Ref: 6/2020/1160/VAR  
Date: 12/06/2020

## HISTORIC BUILDINGS AND CONSERVATION ADVICE

**RE: Northaw House, Coopers Lane, Northaw, Potters Bar, EN6 4NG**

The application is for the variation of condition 25 (approved plans and details) on planning permission 6/2019/0217/MAJ.

PROPOSED FRONT ELEVATION, SETTLEMENT UNIT 1

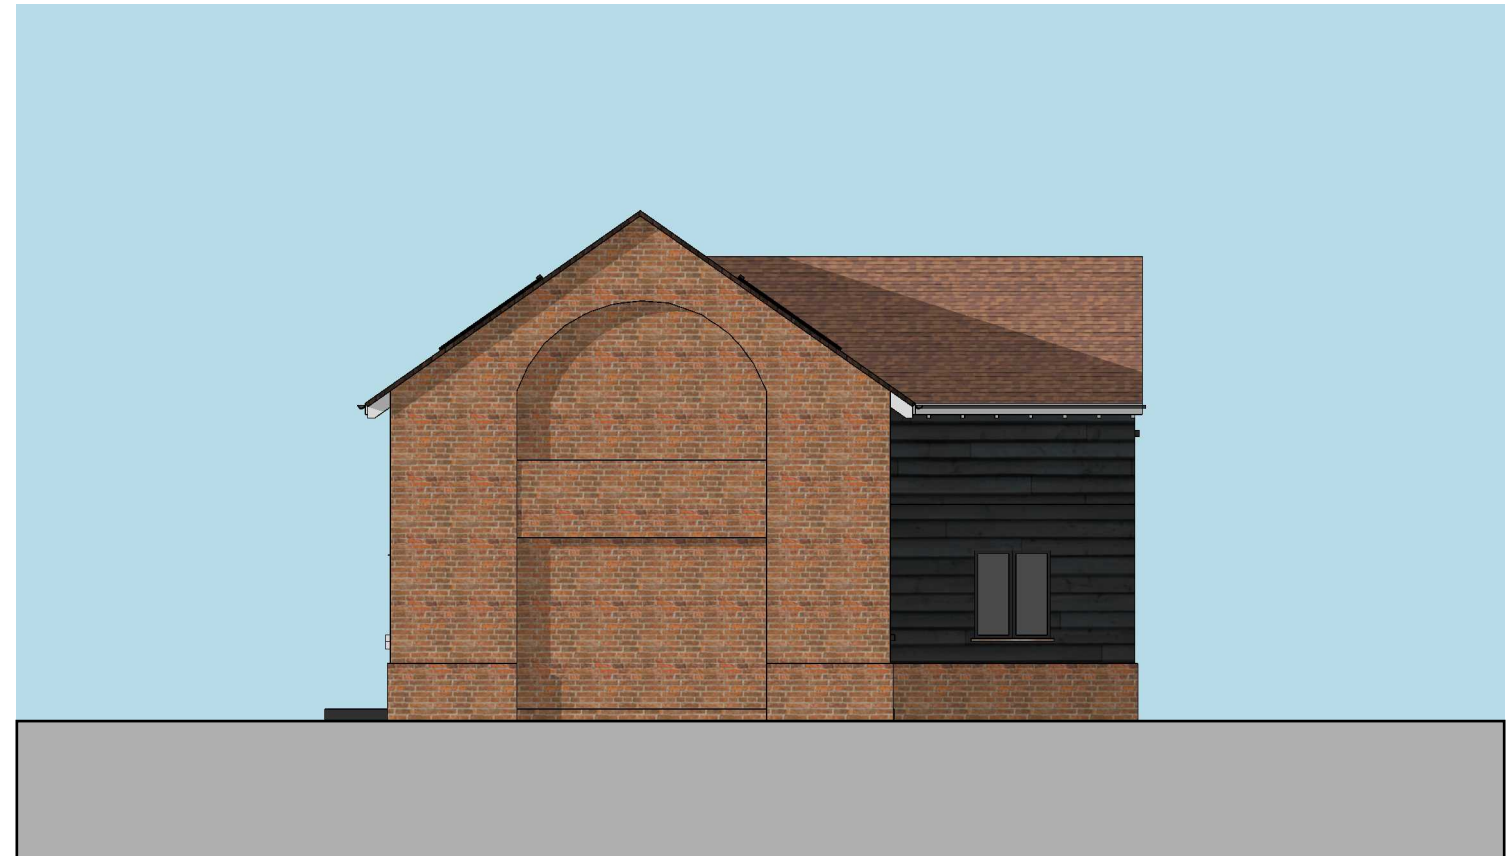
There are no objections to the amendments to Settlement Units 1 and 2 to introduce black timber weatherboarding to all elevations as per 6/2020/0930/VAR (variation of condition 4). However, the submitted drawings should be revised to reflect the change from brick to weatherboarding (to align with the revisions under 6/2020/0930/VAR).
